Responses to Comments

El Paso County

CANTERBURY DR & HIGHWAY 105  
INTERSECTION SIGHT DISTANCE  
NOT TO SCALE

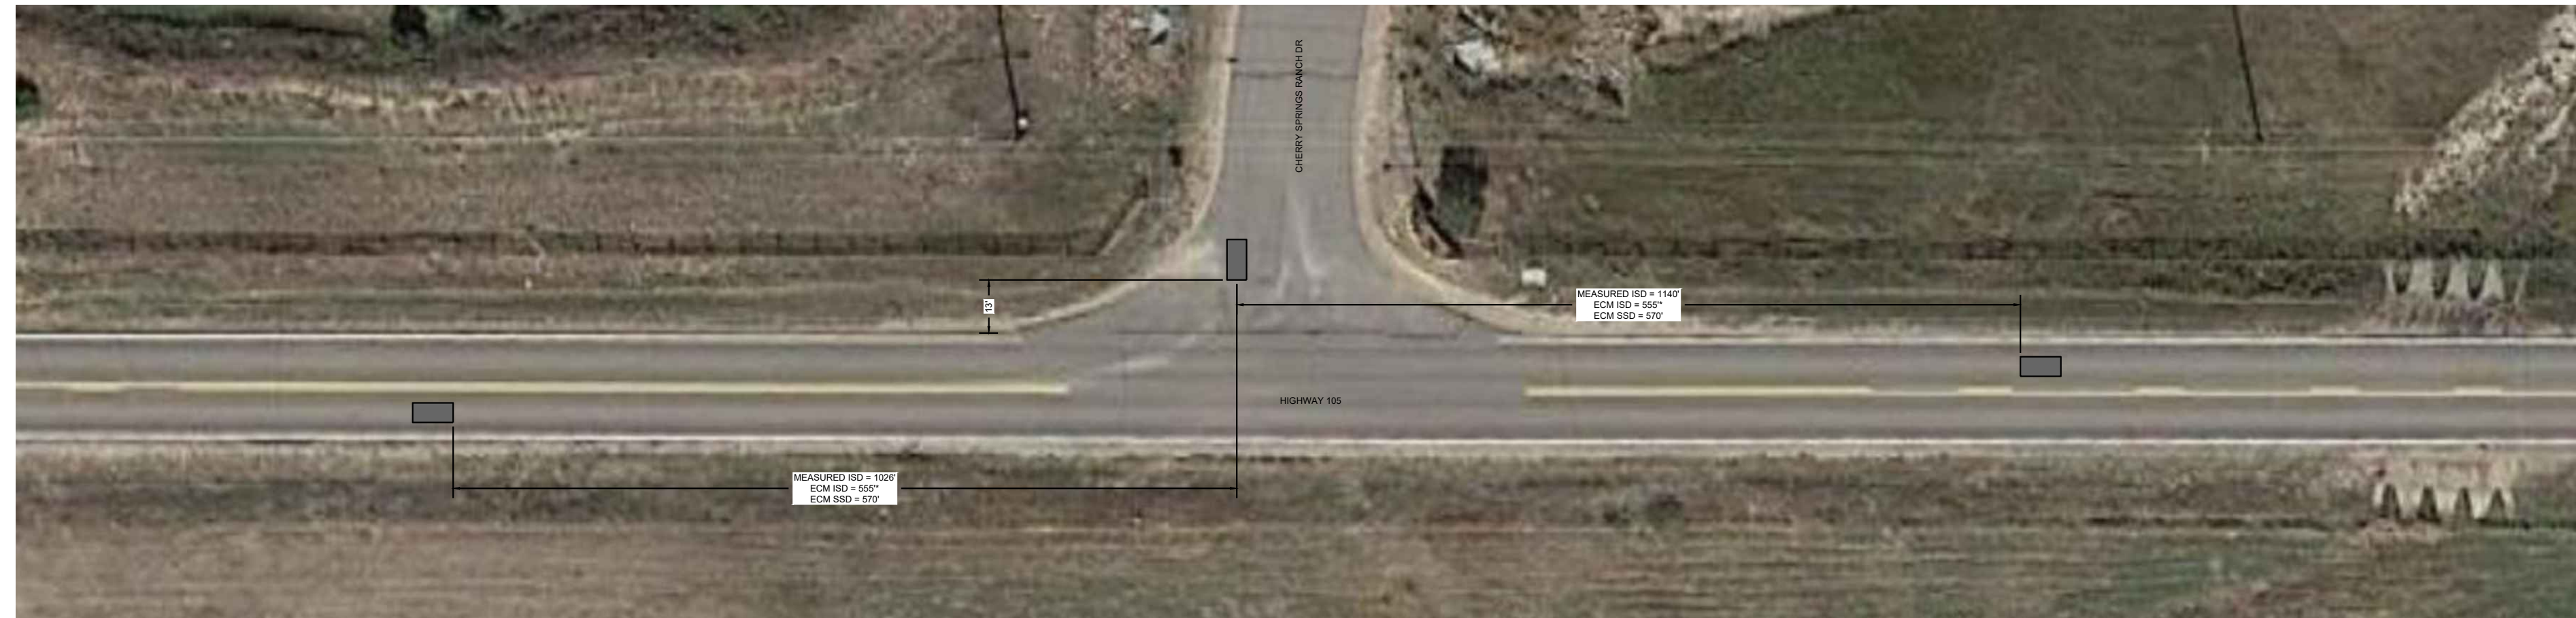
- Update to provide ECM sight distance requirements in the narratives above and compare to what is out in the field. Also list ECM criteria for stacking, storage, and taper for every affected auxiliary lane and access and state whether this access can be met. If it cannot be met, state the required modifications so that it can be met. **Sight distances, and ECM criteria added to existing conditions section of report. Auxiliary lane requirements added to auxiliary lane analysis section of report.**
